2020/93308 Former Spotted Cow New Hey Road, Salendine Nook.

Highway Development Management's (HDM) comments for the above application as follows:

Planning application for erection of A1 foodstore with associated parking provision. Access to the site is via the former spotted cow public house entrance taken directly onto the A640 New Hey Road. The site is designated within the Council's Local Plan for housing.

PROJECT	Lidl Store New Hey Road, Huddersfield			
DRAWING TITLE	Retaining Wall Sections

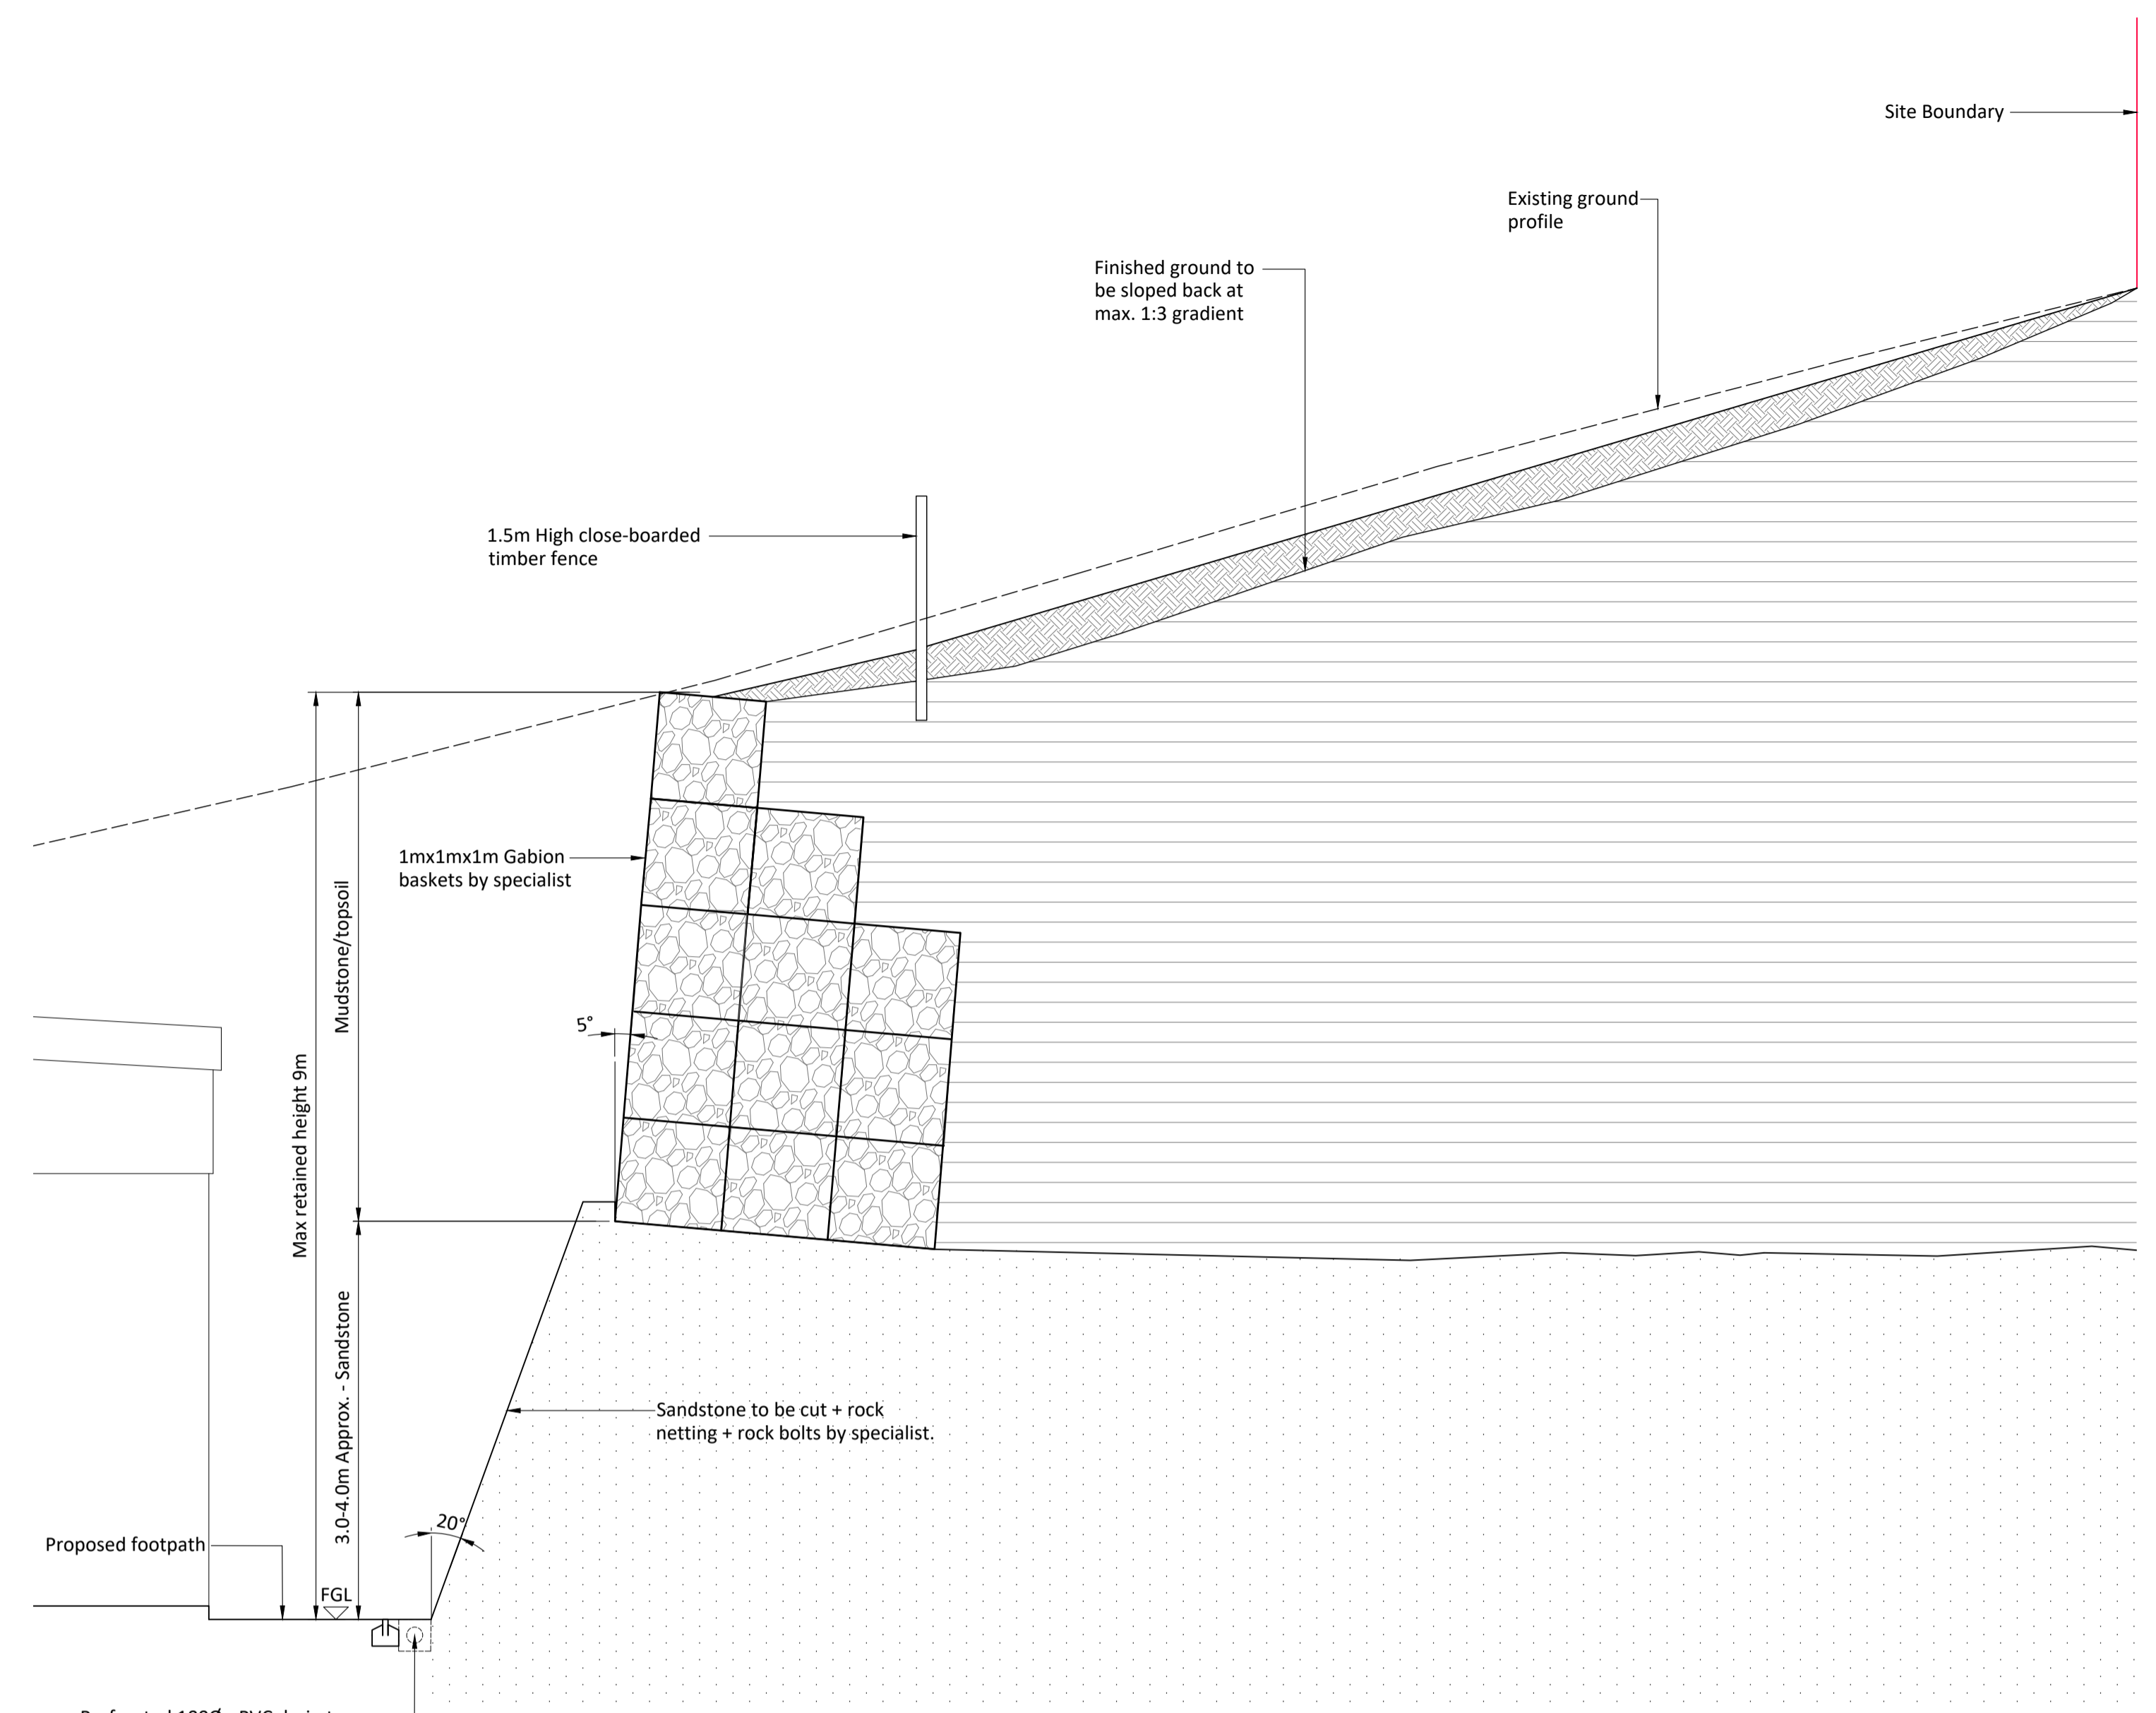
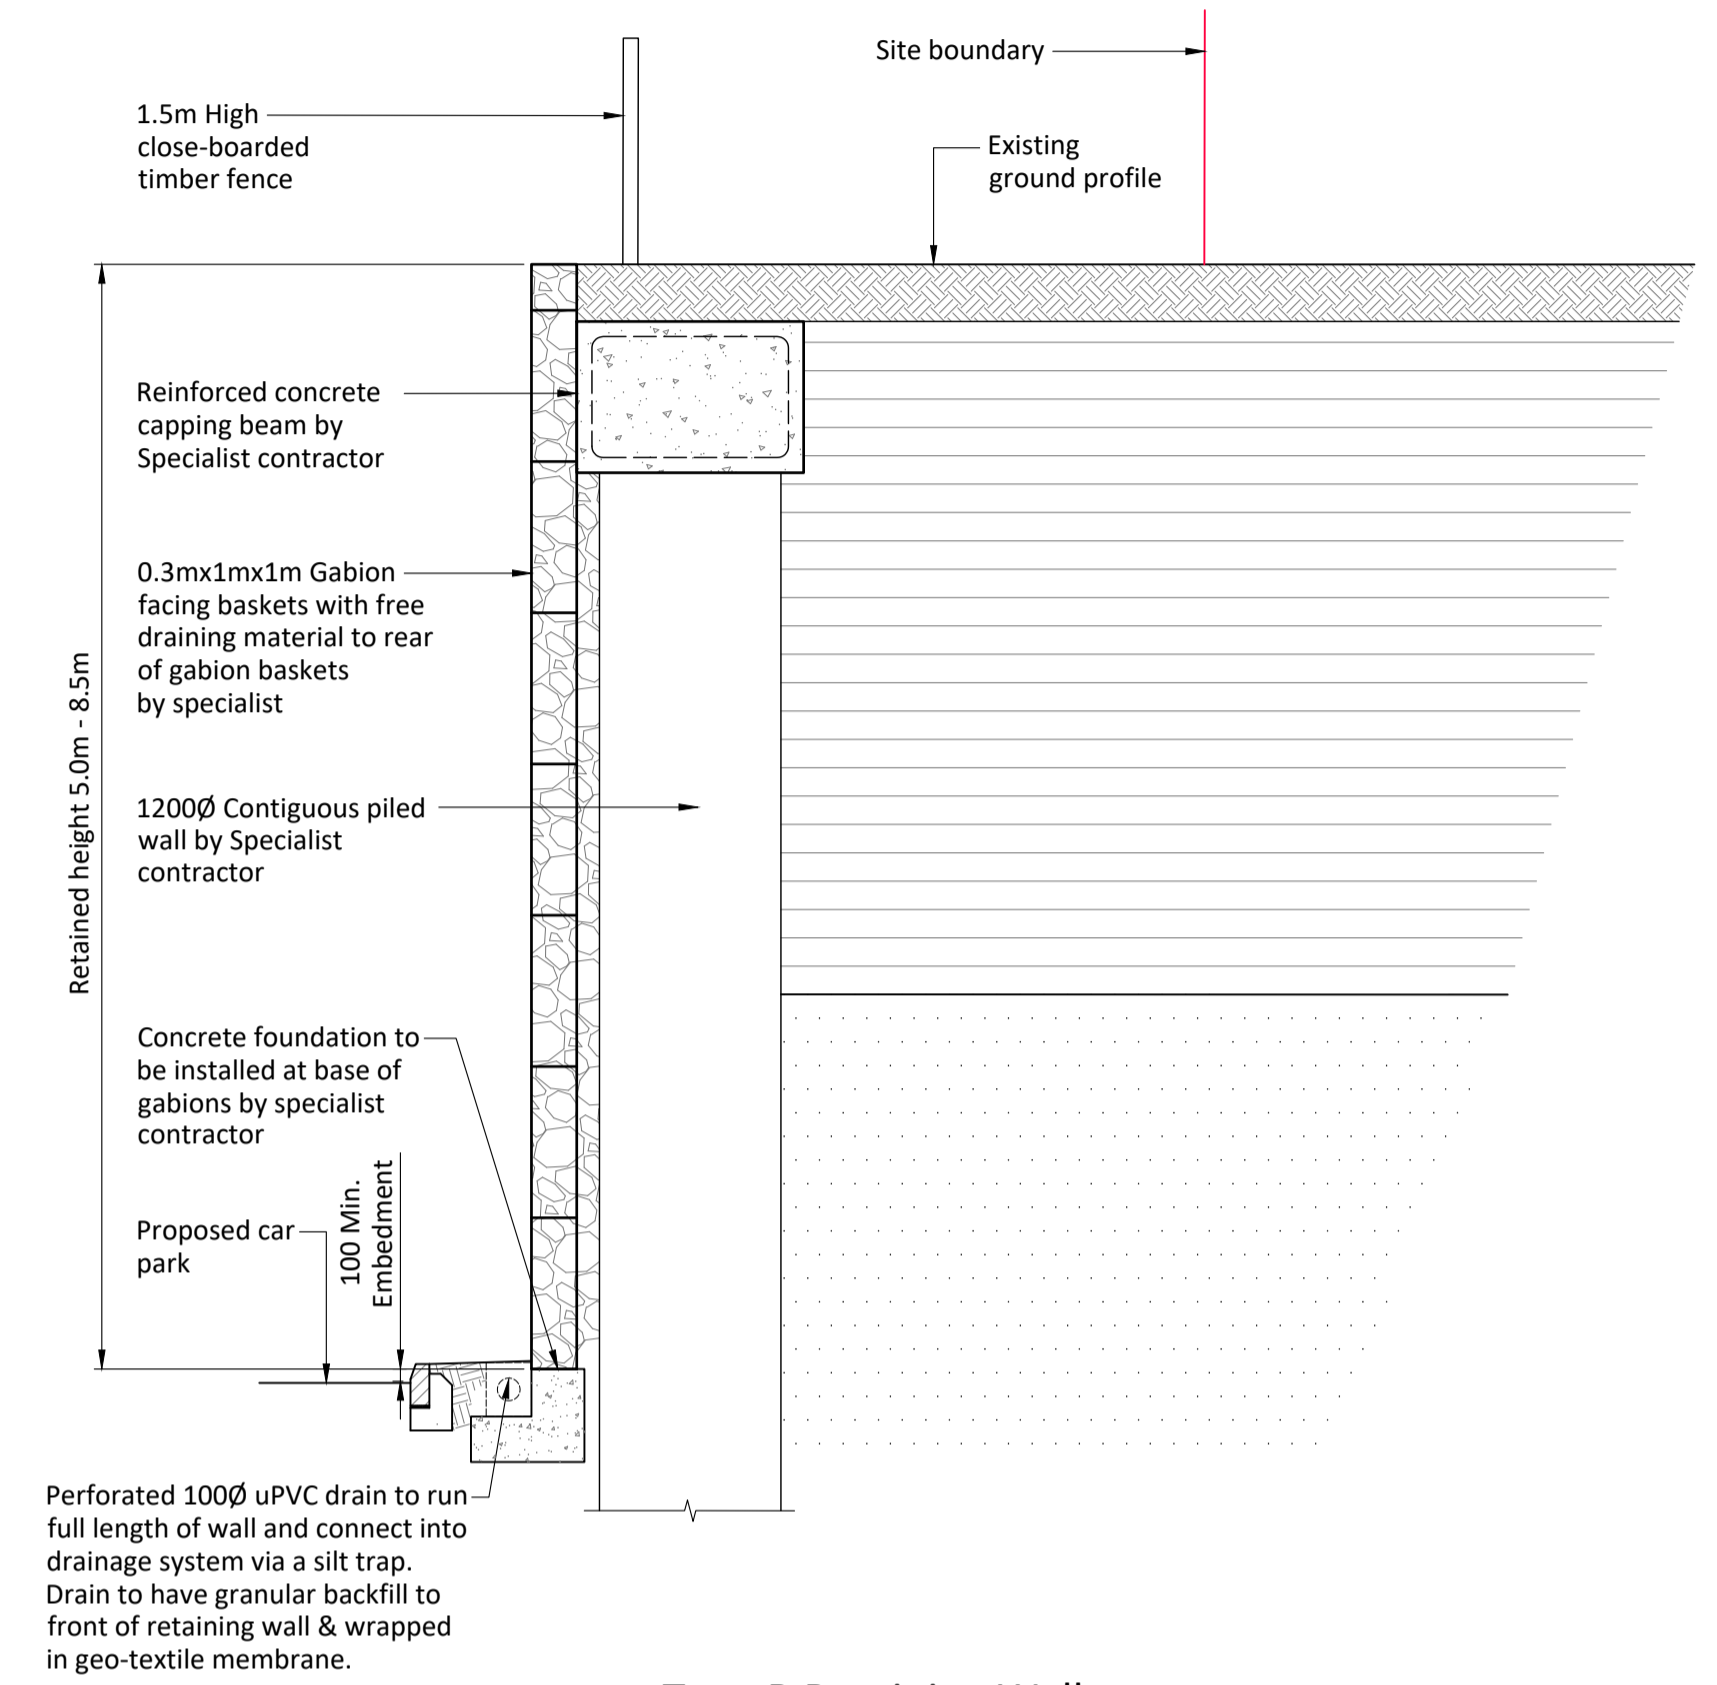
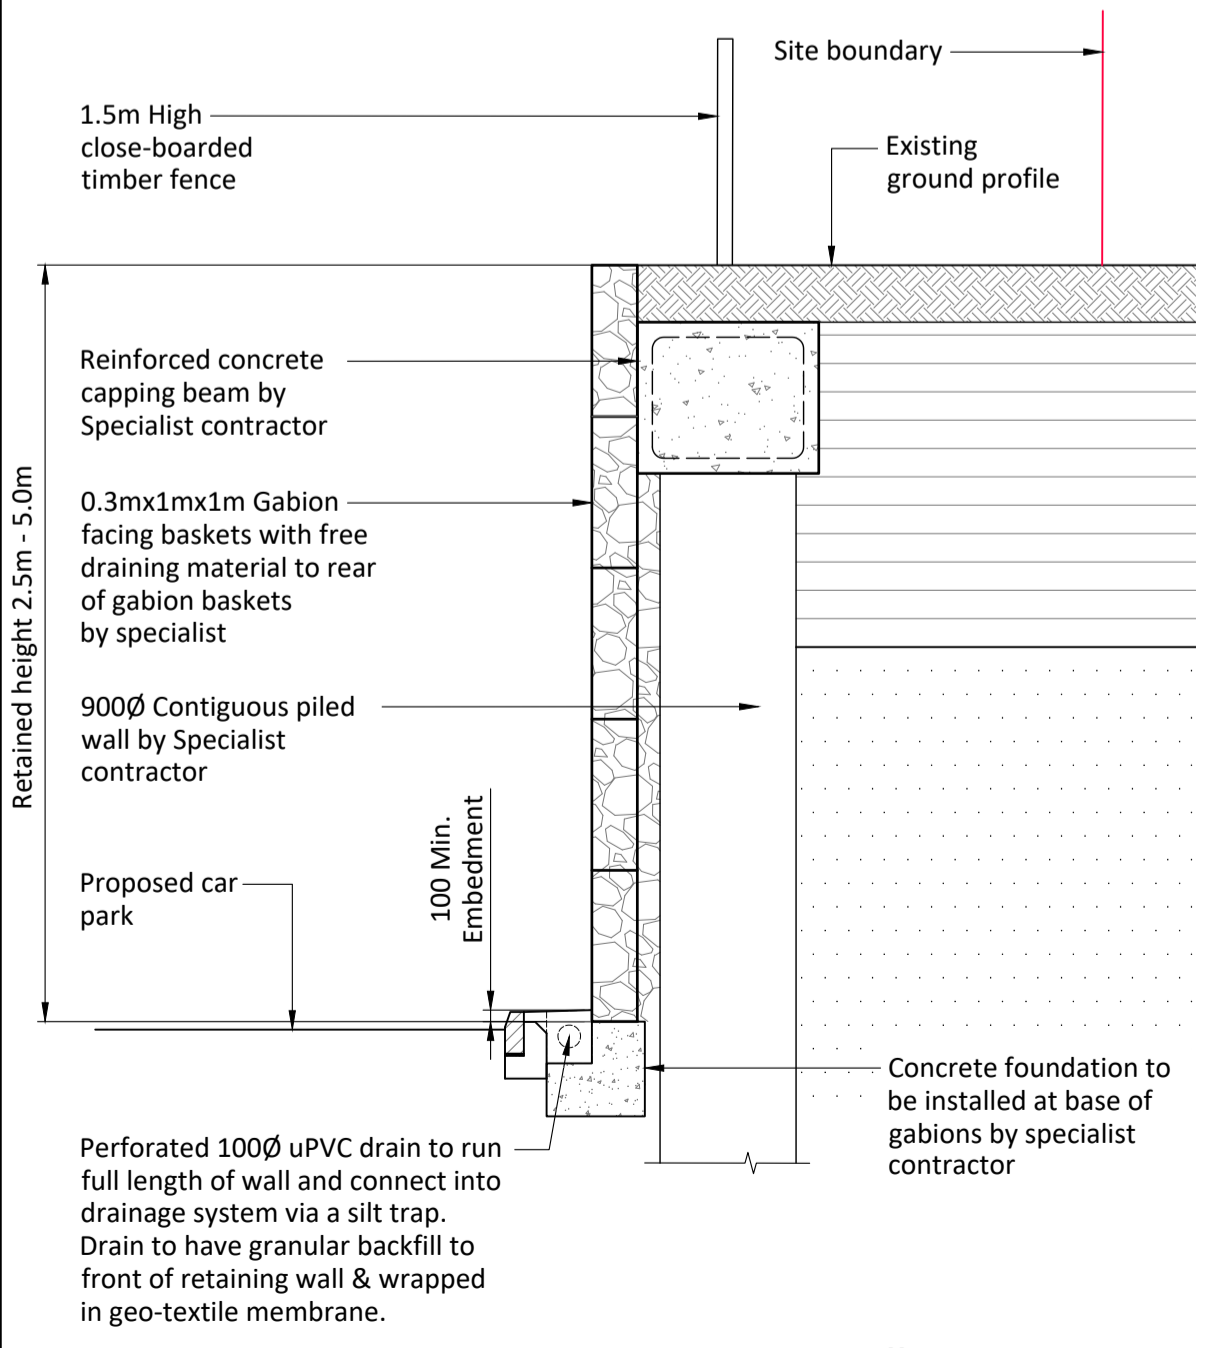
Retaining walls.

Before the development commences a scheme detailing the location and cross sectional information together with the proposed design and construction for all new retaining walls/ building walls adjacent to the existing/ proposed adoptable highways including any modifications to the existing retaining wall supporting the A640 New Hey Road and or PROW 367 shall be submitted to and approved by the Highway Authority in writing. The approved scheme shall be implemented prior to the commencement of the proposed development and thereafter retained during the life of the development.
